From: Maria Tomalova <Maria.Tomalova@arun.gov.uk>
Sent: Wednesday, September 13, 2023 5:27 PM
To: Planning.Responses <Planning.Responses@arun.gov.uk>
Subject: FW: Y/105/19/PL & Y/106/19/L

Y/105/19/PL & Y/106/19/L

The proposal is for the conversion of, and alterations to, existing barns to create 3 dwellings, along with the erection of car barns, a store, a replacement pump house, demolition of a C20 barn and associated landscaping and parking.

Drawing Title
Proposed Plans - Barn 1

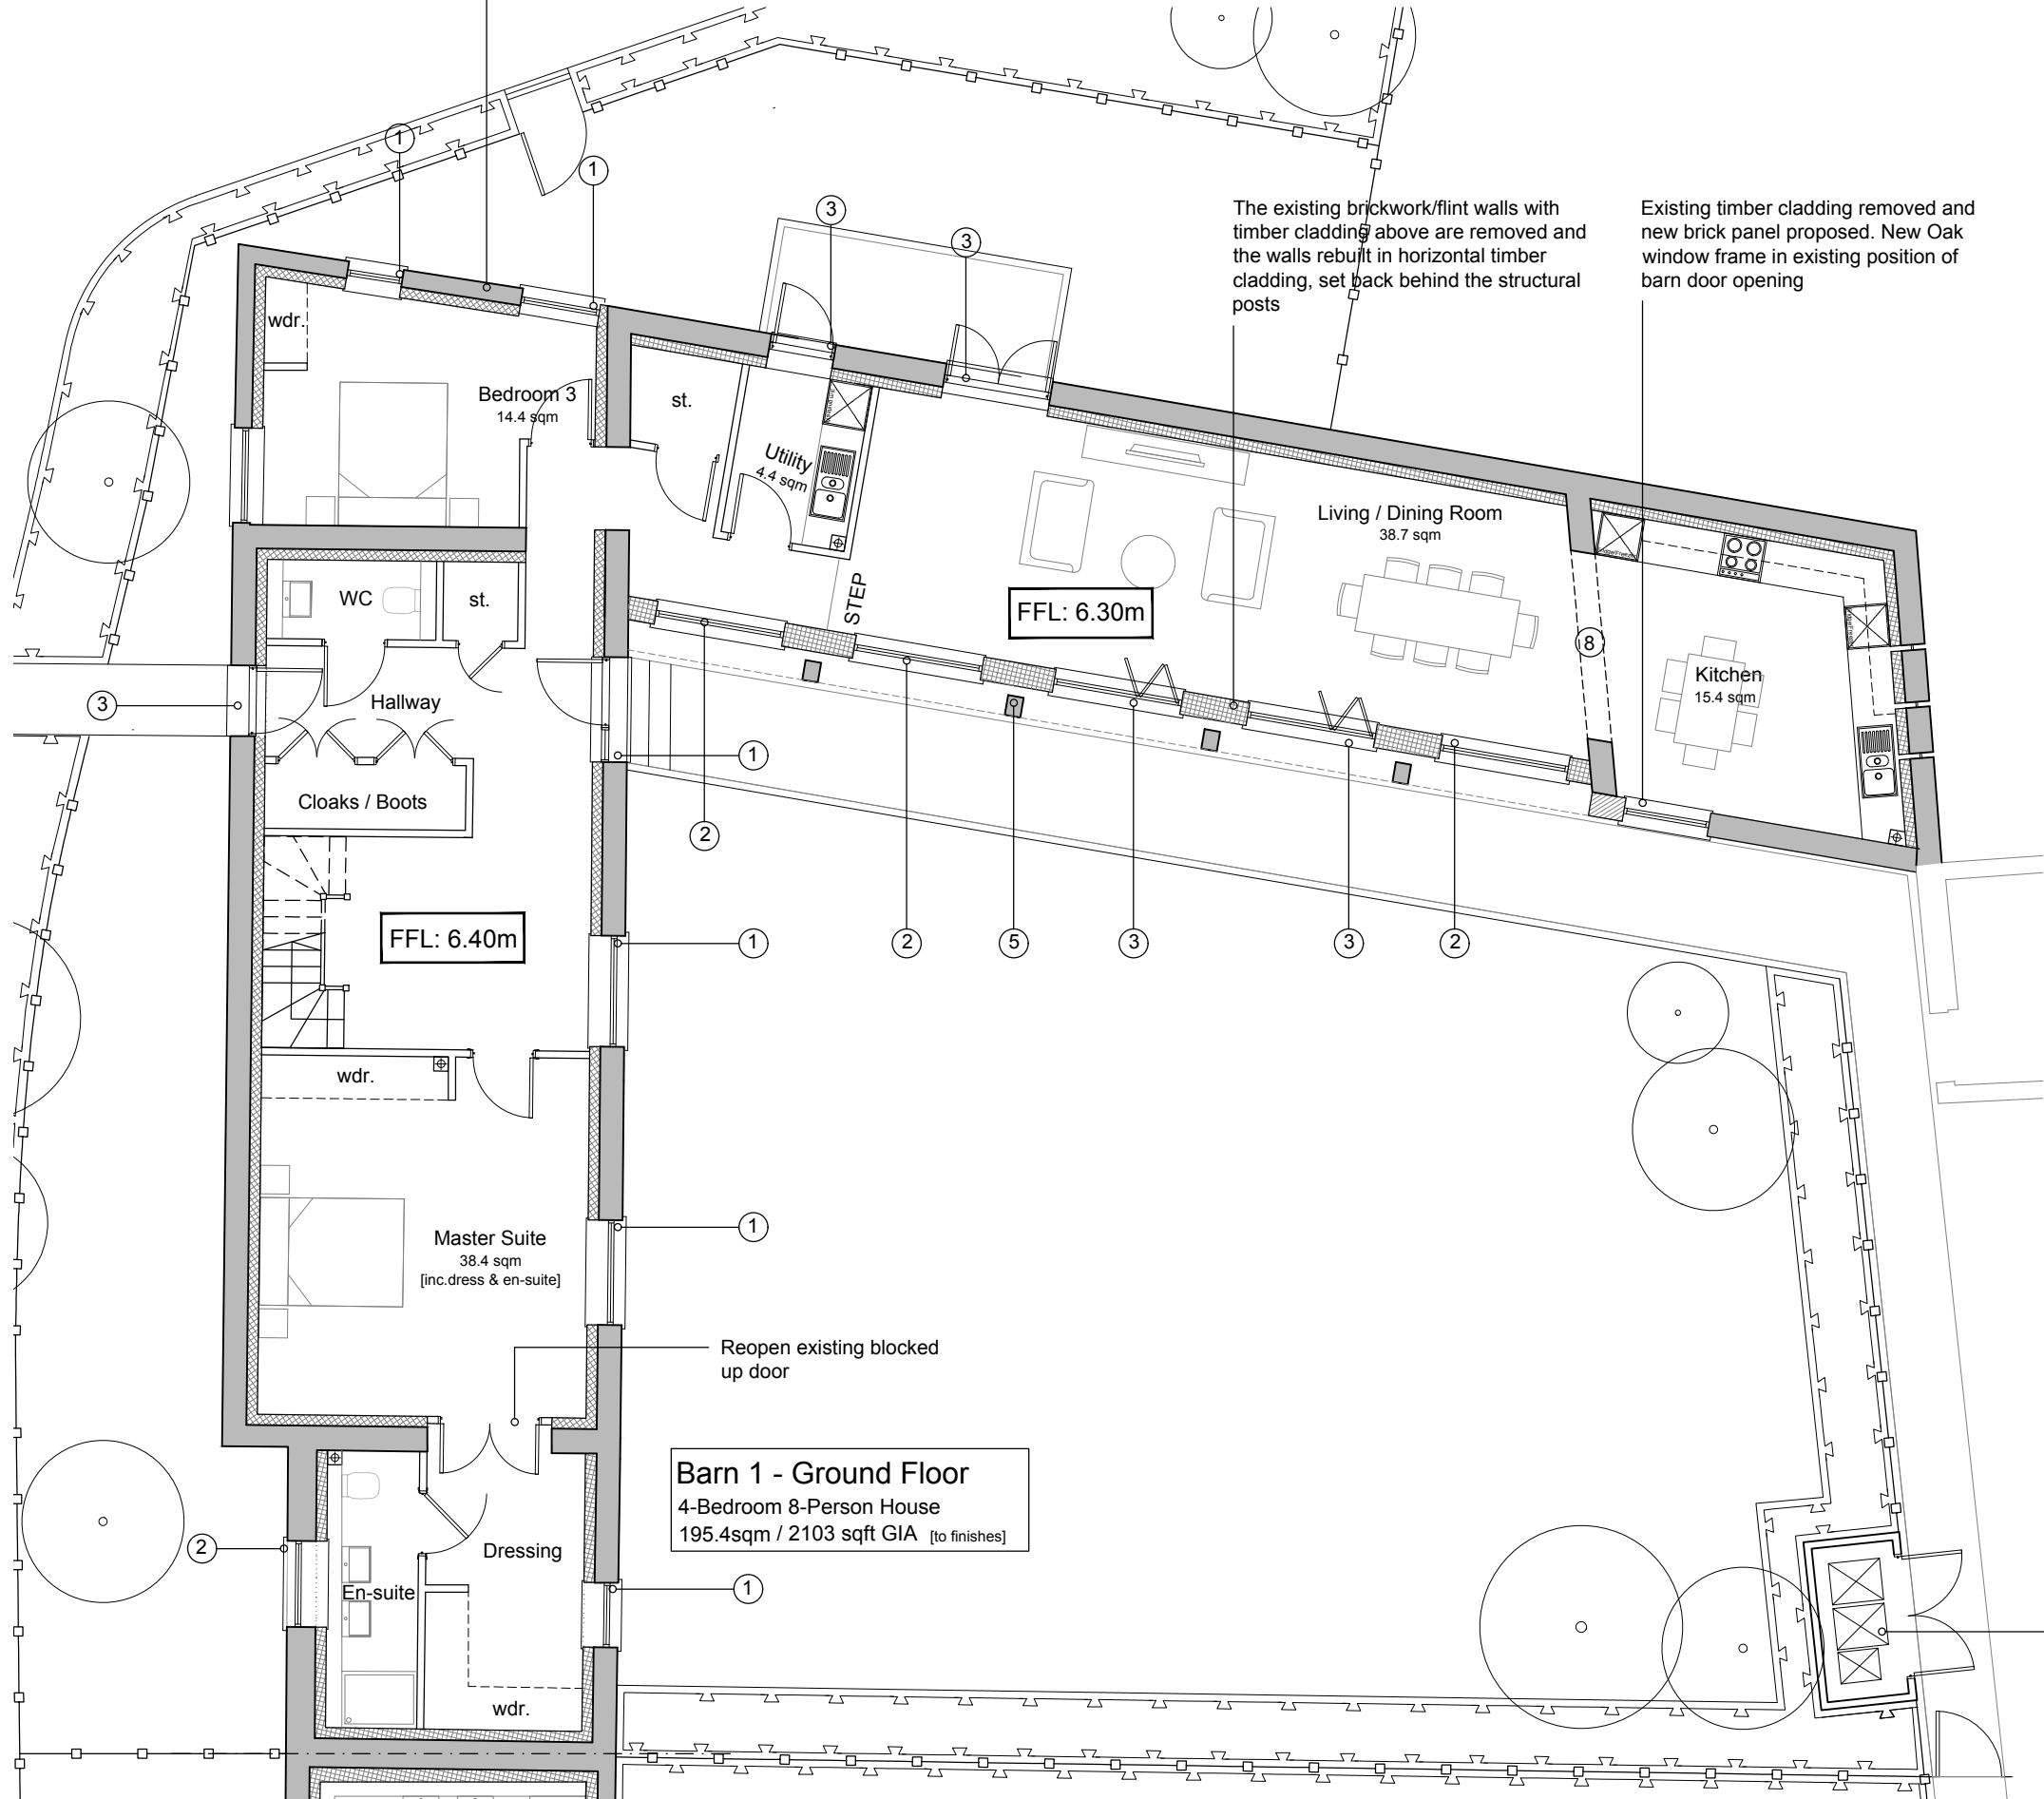
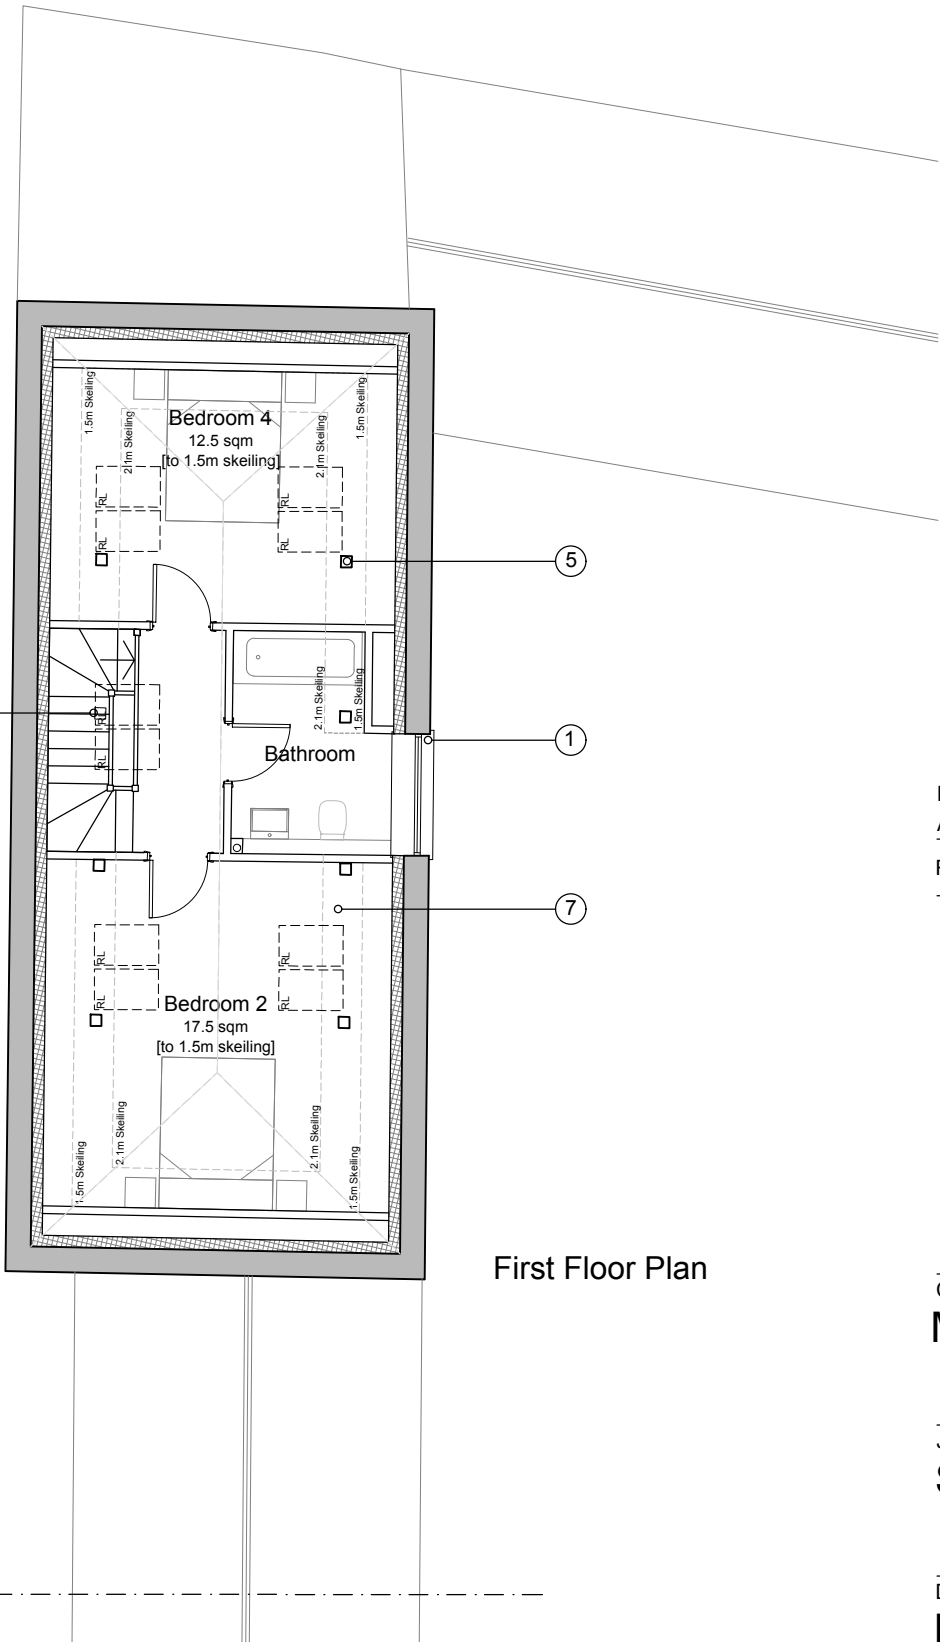
Having undertaken a site visit it is clear that some parts of the barn to be converted into unit one retains some attractive features, especially within the two-storey element. These features are some of the most attractive within the barns. These features include flint flooring, exposed brick walls, timber ceiling and stall dividers. The proposed plans indicate that this area is to be sub-divided up into smaller areas/rooms with a new staircase, yet it is not clear how these important features are to be retained.

Likewise, in building one, it is noted that an elevation will be altered in order to expose the previous cart barn openings. Such a proposal is generally acceptable, but the design of the new elevation, which includes excessive amounts of glazing, should have a simple framed emphasis and be recessed as far as possible to allow a deep shadow line. Such an approach also minimises reflections to reduce the visual prominence of the glazing. This

Likewise, it is noted that the building referred to as 'barn 3' is to include bi-folding doors. Such a feature is not normally associated with a barn and cannot be supported here. It is suggested that an alternative approach be considered which would result in the loss of less historic fabric, and a more appropriate design.

Our design approach has been to accentuate the most attractive features of the barns wherever possible however, but we have had to be realistic on what features we can retain in order to make the houses fit for habitation. For instance, the flint flooring will need to be taken up and appropriate damp proofing, insulation and floor finishes laid to meet building regulation requirements for habitable dwellings. We can however look to re purpose the flint from this area within the car barns or possibly as a feature within the central courtyard space. Similarly, we will need to dress the exposed brick walls with insulation and plasterboard to suitably insulate the dwelling. Whilst the brick wall may not be a feature within the dwelling, this approach will help to protect the wall and offer further longevity to the barns. Where possible the existing timber first floor will be retained as a feature with new insulation and floor finishes dressed on top to meet building regulations for the habitable rooms.

Your comments are noted regarding the window openings and we would assume that they would form part of a planning condition that covers the key construction detailing you wish to be agreed. The window reveals will form part of the detailed design package when the proposed wall build ups are established and we determine how this meets the window/door junctions. In an attempt to reduce the prominence of glazing along the elevation we could reduce the window sets from three pane to two panes, with the door openings becoming simple double opening doors as opposed to bifold. Please see the attached mark up.

Yes, this can be altered to a pair of patio doors which will reduce the size of the opening in the exiting barn. Again, where new external openings are proposed we will look to repurpose the flint elsewhere in the scheme.

Proposed North-West Elevation (A)

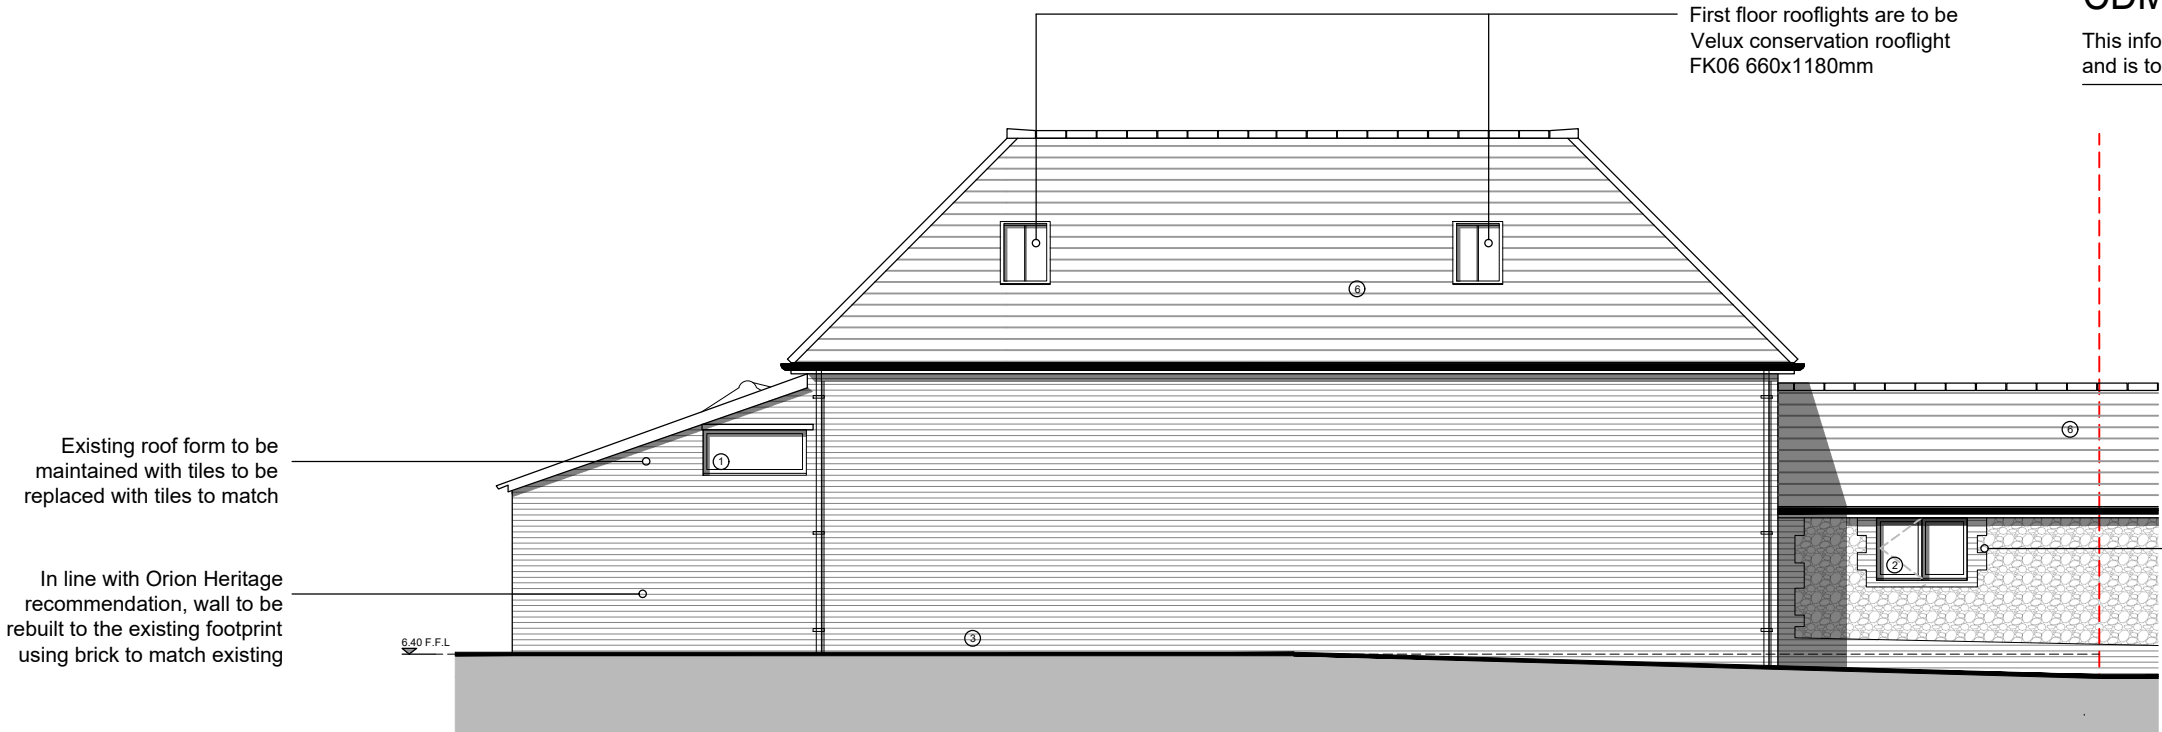
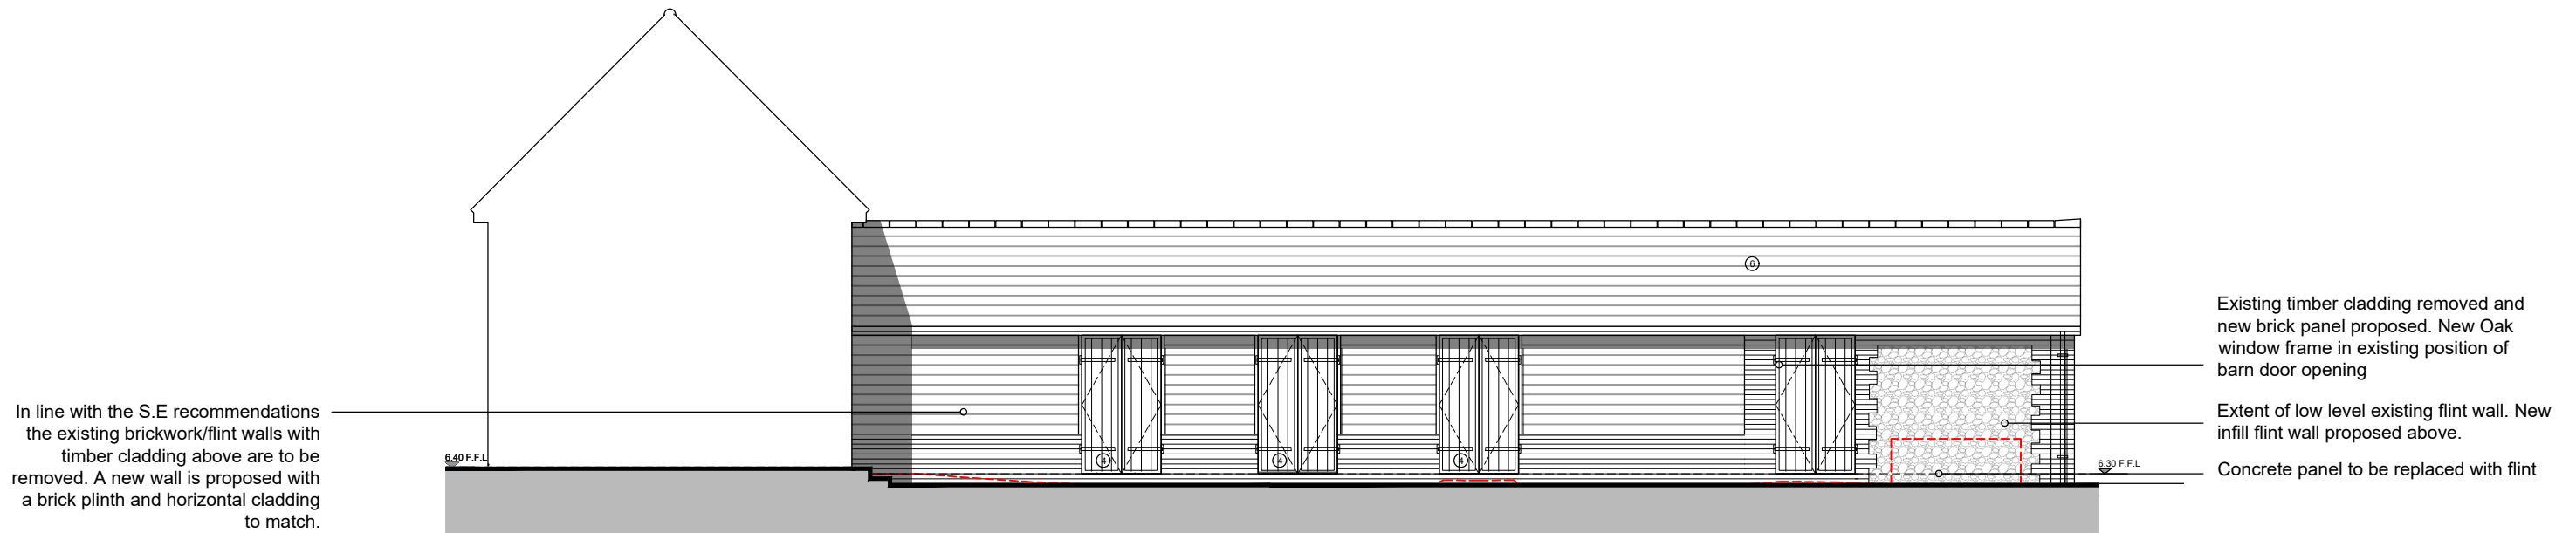
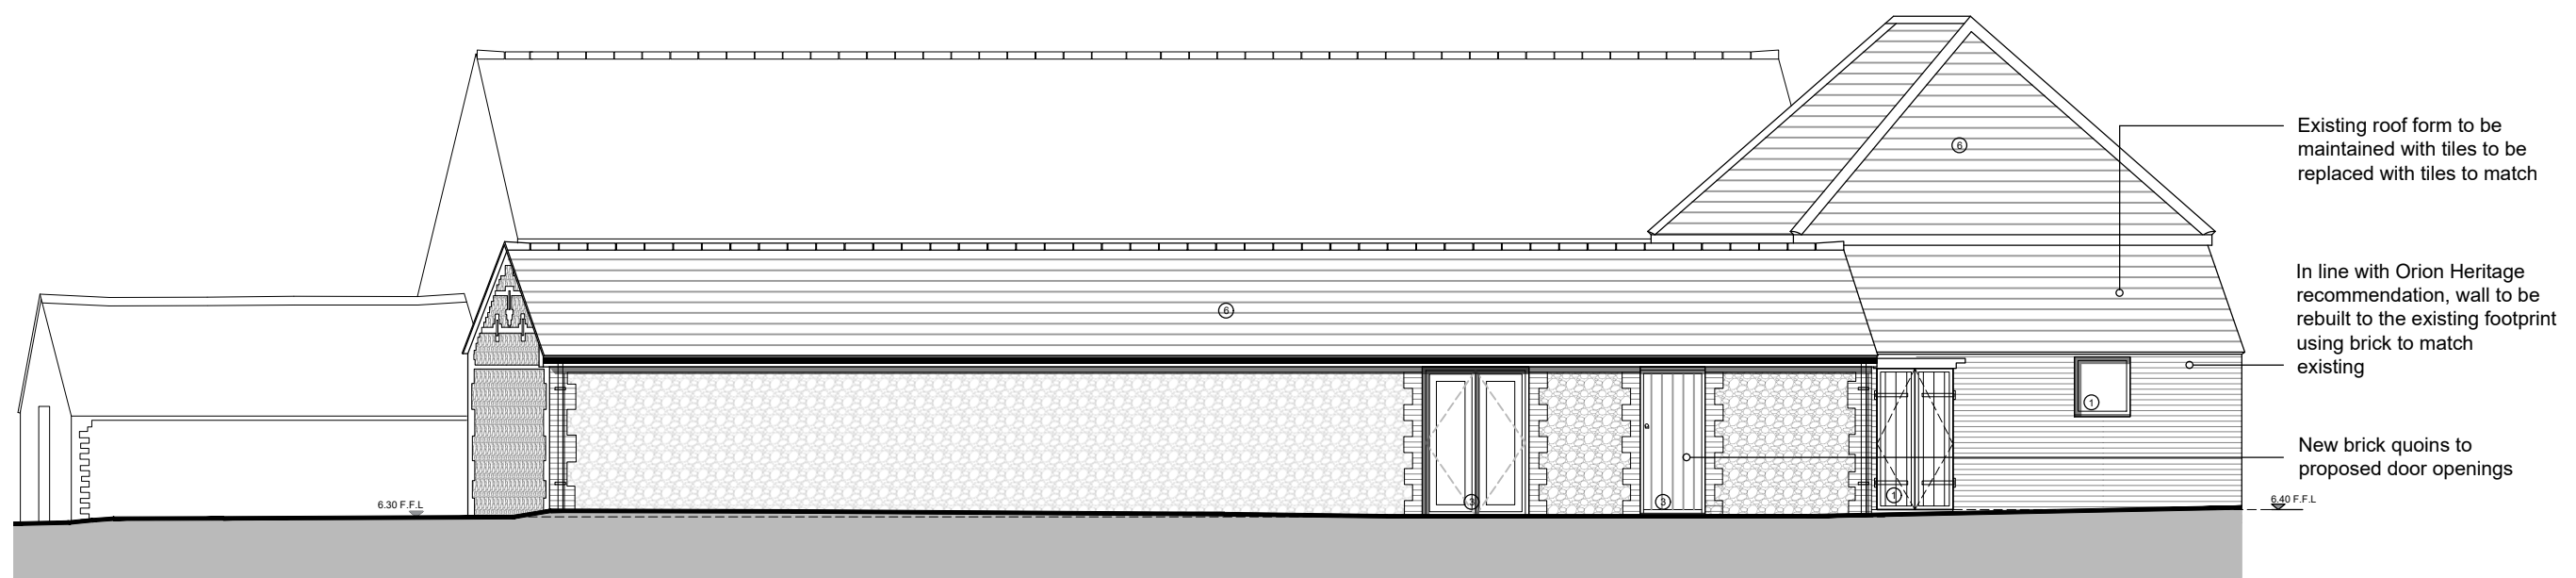
There is some concern regarding the amount of rooflights proposed. Are so many necessary?

It is intended for these rooflights to be conservation lights which are more sympathetic to the existing character of the barns. With this being said there are some areas within the scheme where the number of rooflight can be reduced, please see our mark-up of the plans an elevation for a suggested solution.
